Application: SSI 7485

I write regarding the proposed modification to M4-M5 Link, Mod 2 The Crescent overpass and changes to pedestrian infrastructure in North Annandale, Rozelle and Rozelle Bay Foreshore area.

Figure 4-2 Pedestrian and cyclist bridge infrastructure options

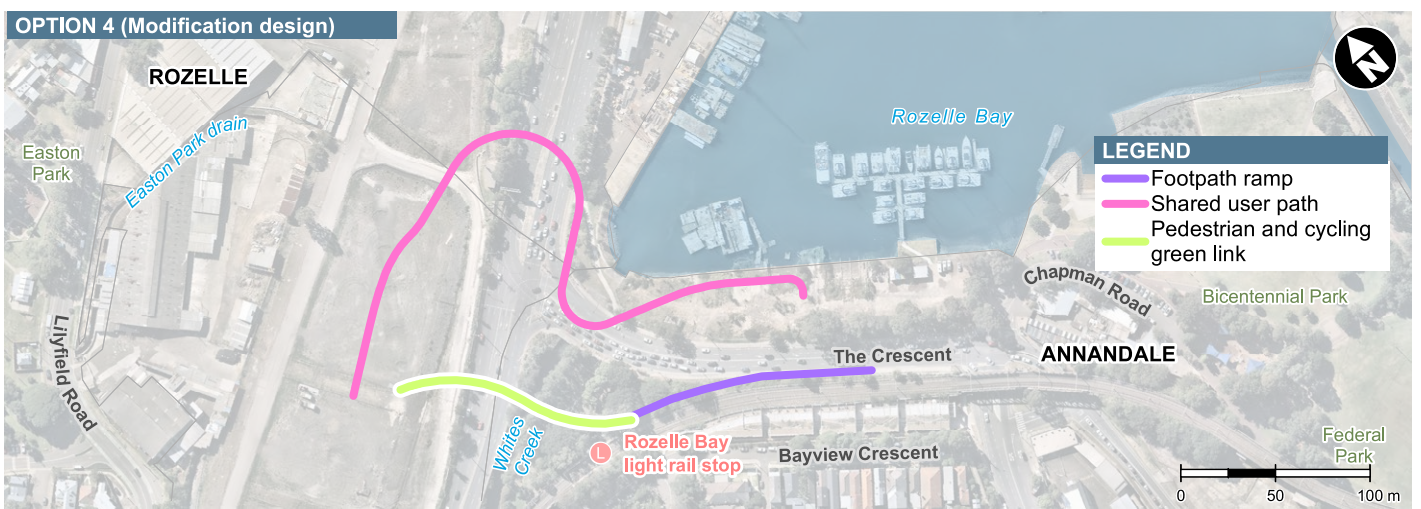
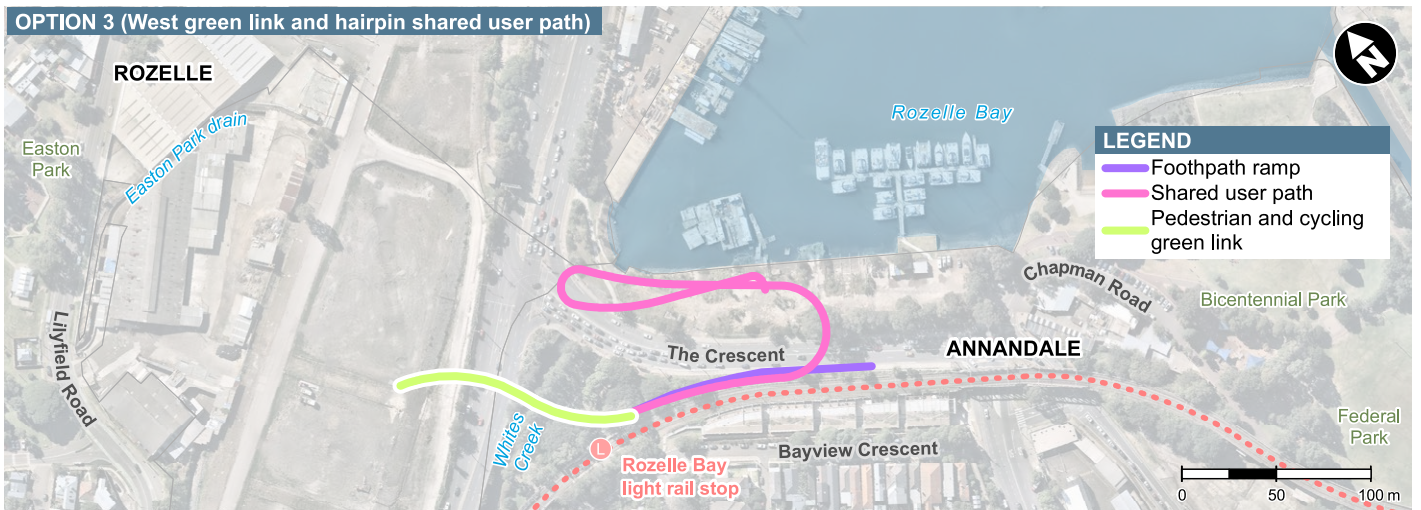
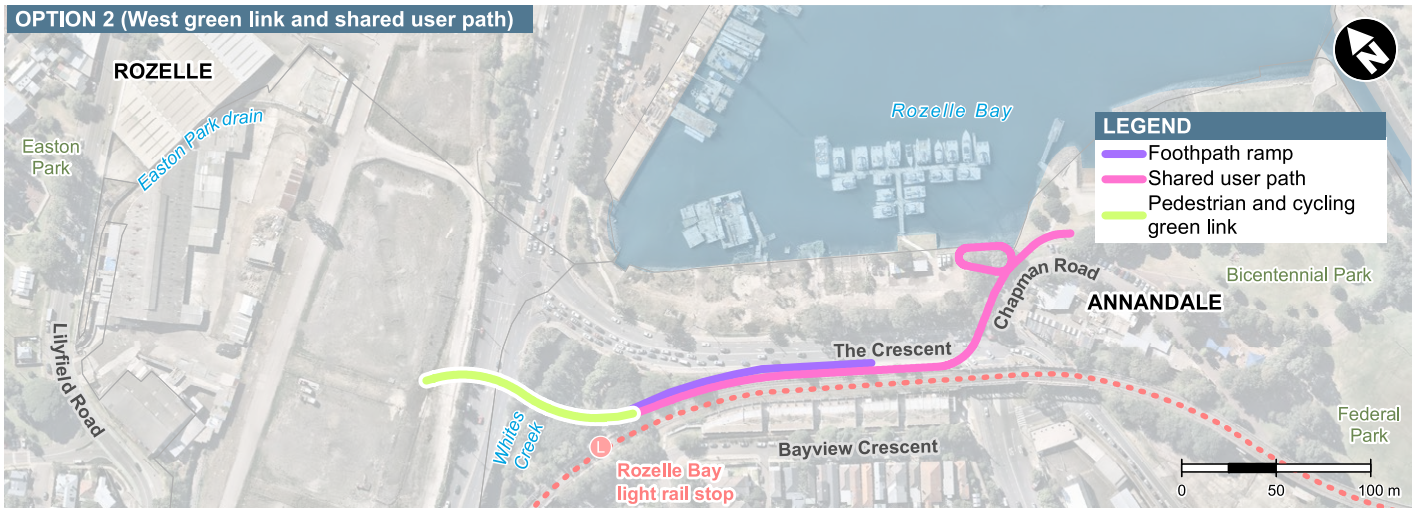
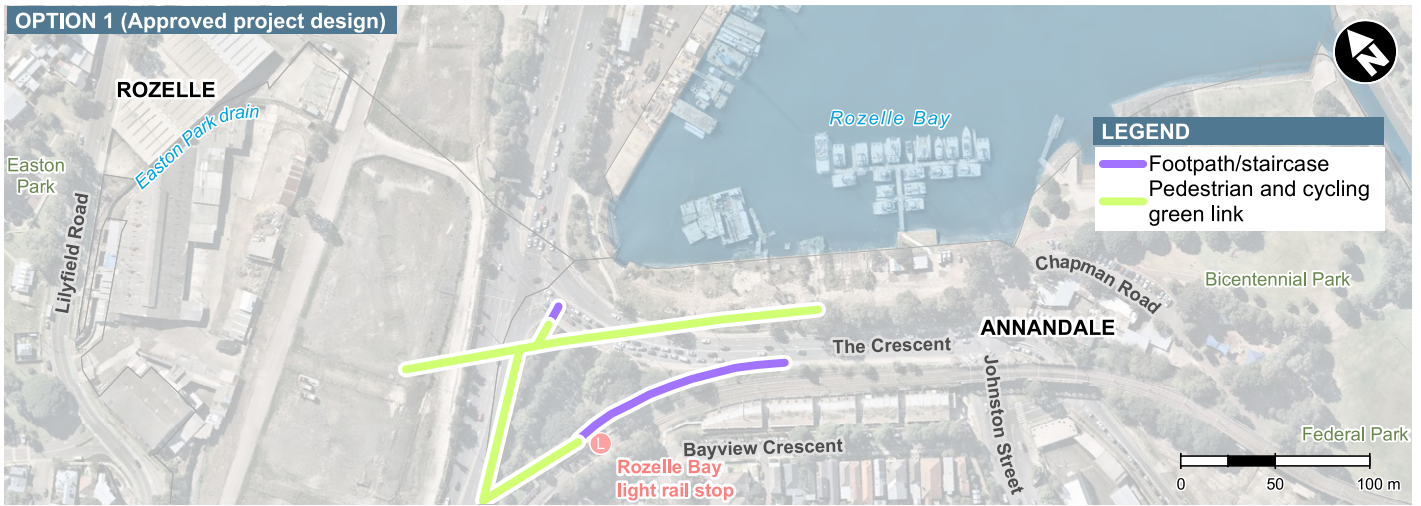
I request RMS work with the community to explore alternate design options to the proposed new car overpass design and the changed pedestrian and cyclist links. I am seeking the reinstatement of the safe, direct access from the approved EIS GreenLink to create a continuous green open space connection from the Rozelle Rail yards and Annandale to the foreshore. The GreenLink was more than just a walk way - it put people central to the design, maximising safety, and providing much needed accessible open space for the community now and into the future Bays Precinct design.

- The significantly reduced safety and increased risk for pedestrians and cyclists with removed access over The Crescent to Bicentennial Park and the increased traffic along Johnson Street.
- Being required to cross five sets of pedestrian lights at The Crescent as my option to reach the foreshore from Annandale or from Rozelle light rail stop.
- Removal of direct active links to the foreshore, cutting the community off from the area and the proposed revitalisation of the entire Bays Precinct, including linking the Light Rail and Bus stops to a Ferry wharf and Metro station.
- Urban and landscape design that is being built before a finalised Masterplan for the area.
- Traffic changes that limit movements around the suburb and create further congestion in the local streets of Annandale, Forest Lodge, Glebe, Lilyfield and Rozelle with no planning to deal with these.

- Reinststate the GreenLink connecting communities and green open space from Rozelle to Bicentennial Park.
- Relocate and design pedestrian and cyclist connections that are continuous, safe and direct.
- Design the modification infrastructure and active links in response to the character of the suburbs, the location of the foreshore and it's potential future development.
- Provide pedestrian and cyclist paths that maximise people safety and do not force us onto busier streets, unsafe concrete plazas and caged walkways.
- Integrate active and direct connections to all active transport – including the future Metro
